Objection Letter - Planning Reference: A/266/21/PL

Application Address Crete House, Dappers Lane, Angmering, Littlehampton, West
Sussex, BN16 4EN

Proposal - 2 No. 2 storey extensions, replace existing bay window with bi-fold doors
on the existing dwelling and the construction of 2 No. 5 bed new dwellings. This
application is in CIL Zone 2 and is CIL liable as new dwellings

SITE PLAN & VISIBILITY SPLAY
1:200

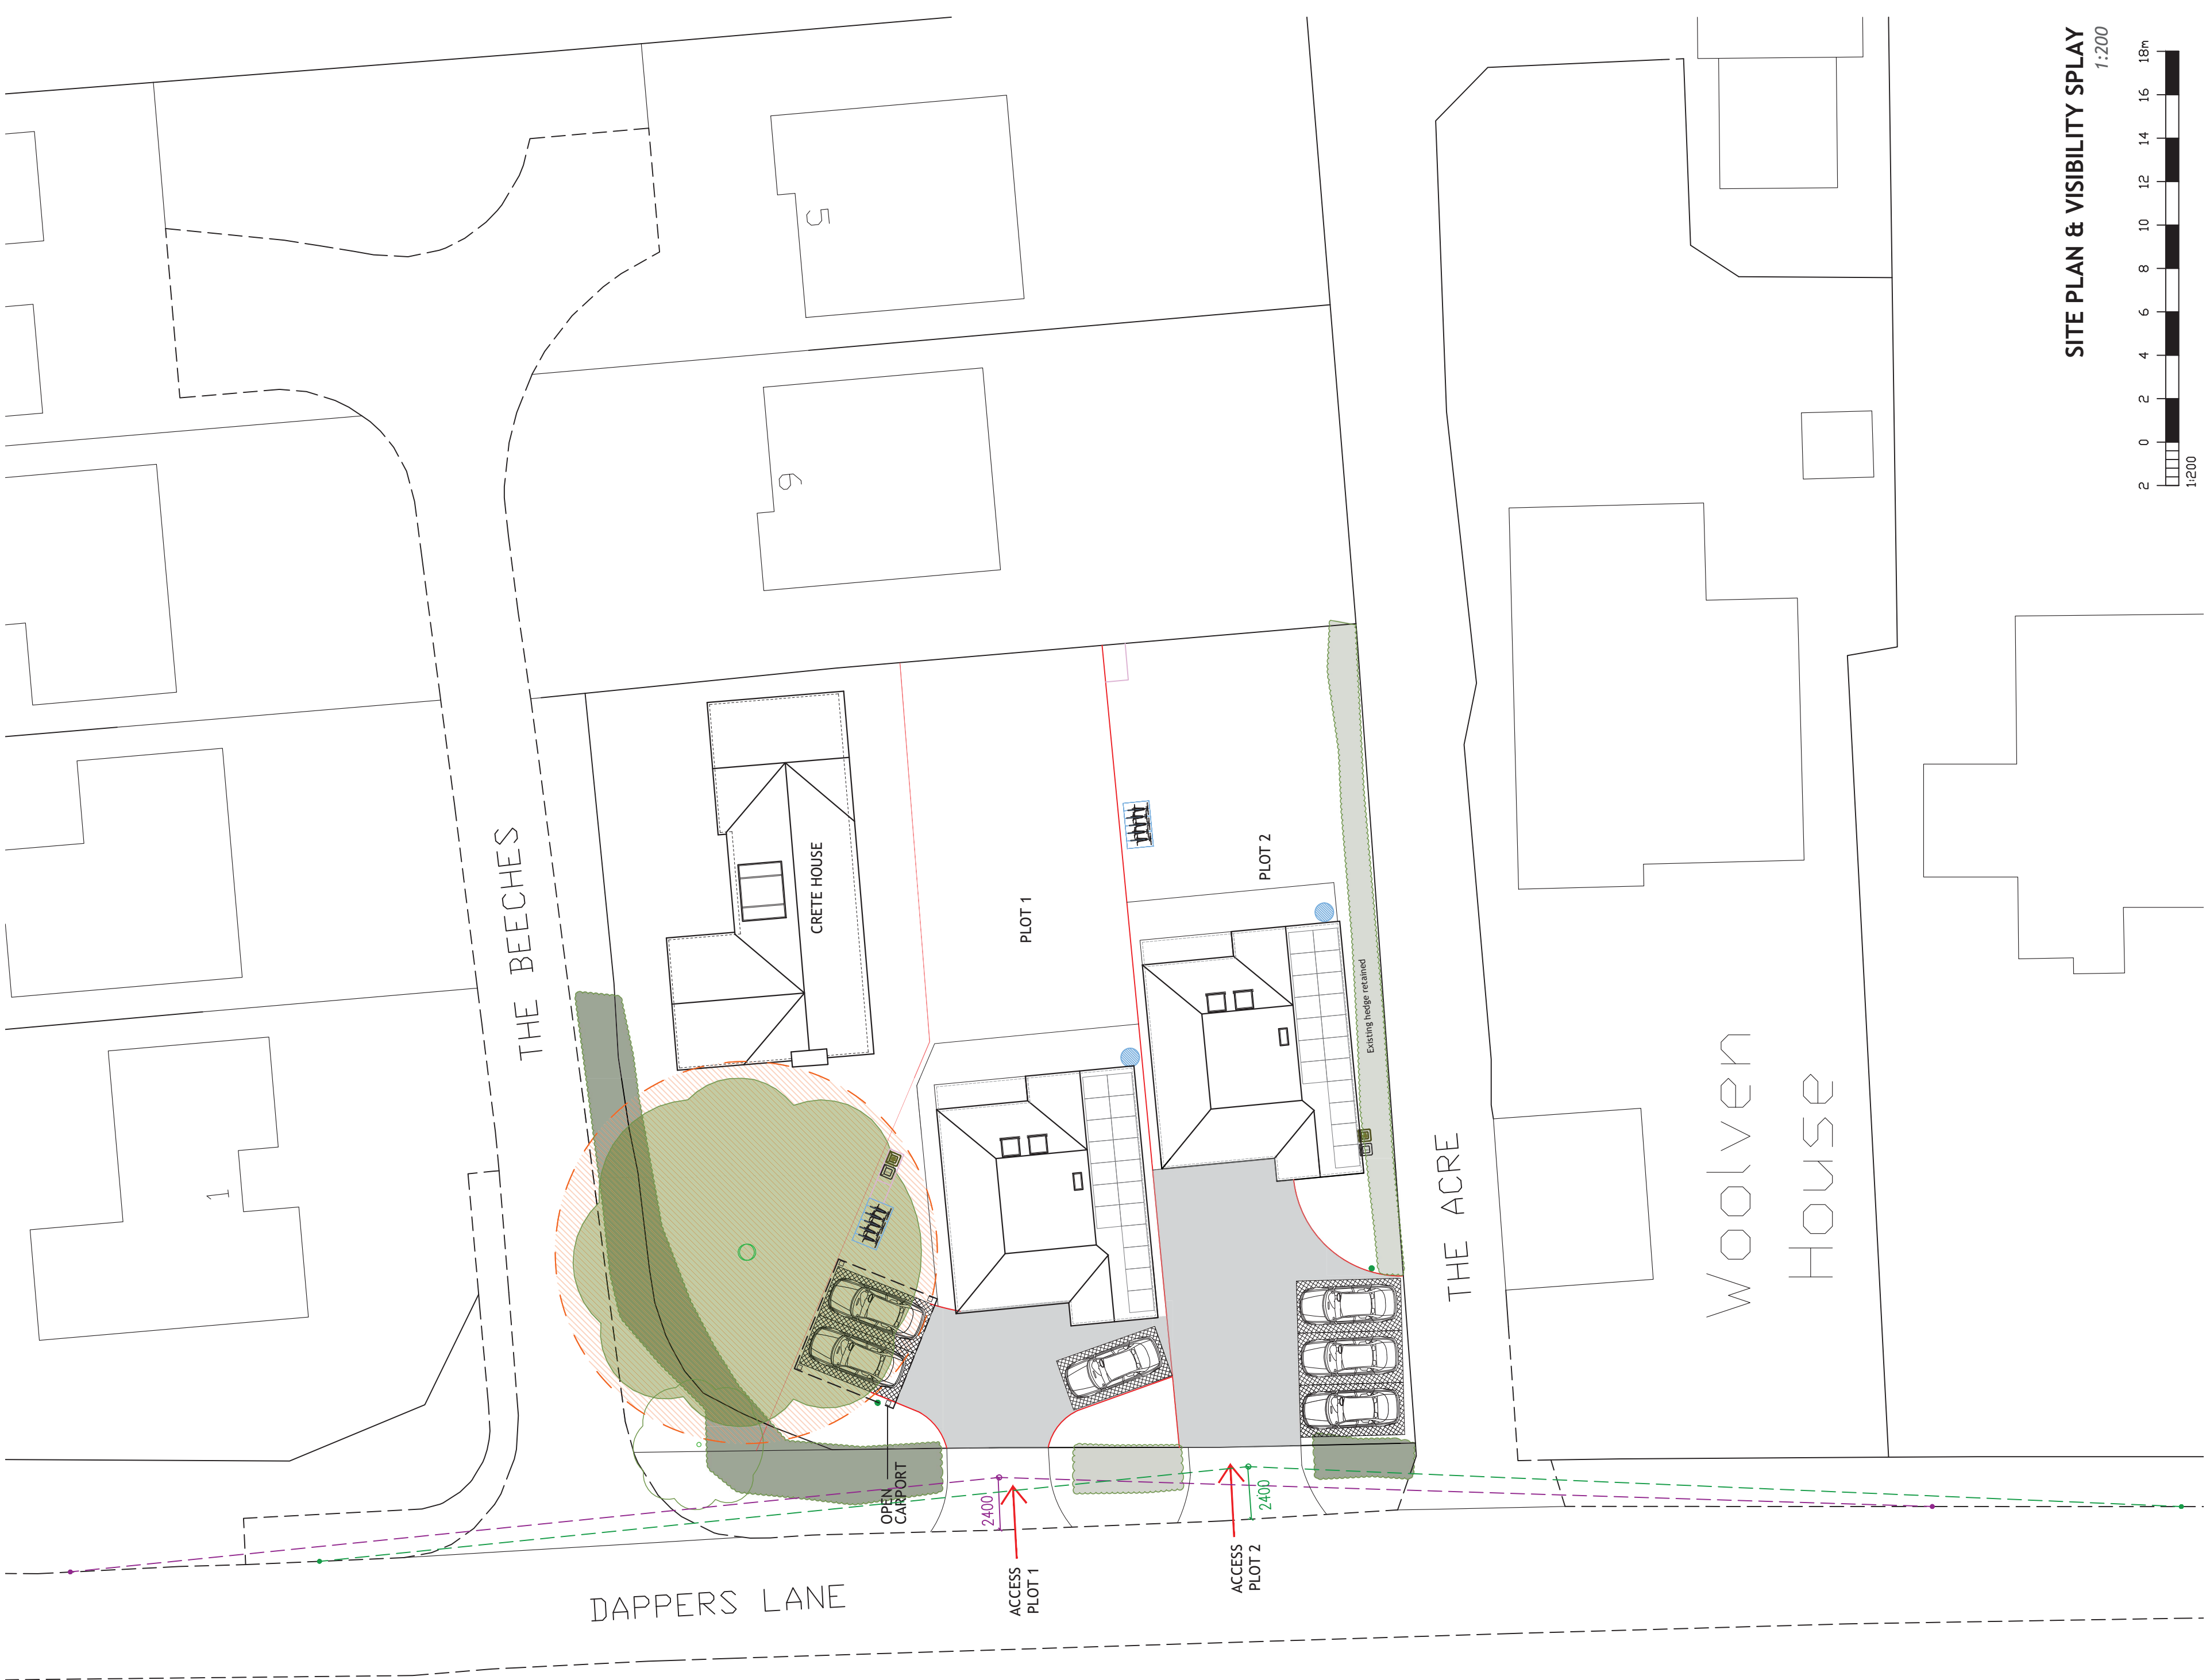
The proposed site plan is again ambiguous as it does not illustrate how vehicles including delivery vehicles can access, park and turn safely within the site. No tracking plans or details of the access arrangements have been provided in respect of the requisite visibility splays that can be achieved on to the highway. Indeed, it appears that the visibility splay required includes land that is not under the control of the applicant. It has not been demonstrated that suitable access to the development can be provided. Further to this the overall width of the access road proposed is too narrow without any footways that will increase the conflict between pedestrians and cars.
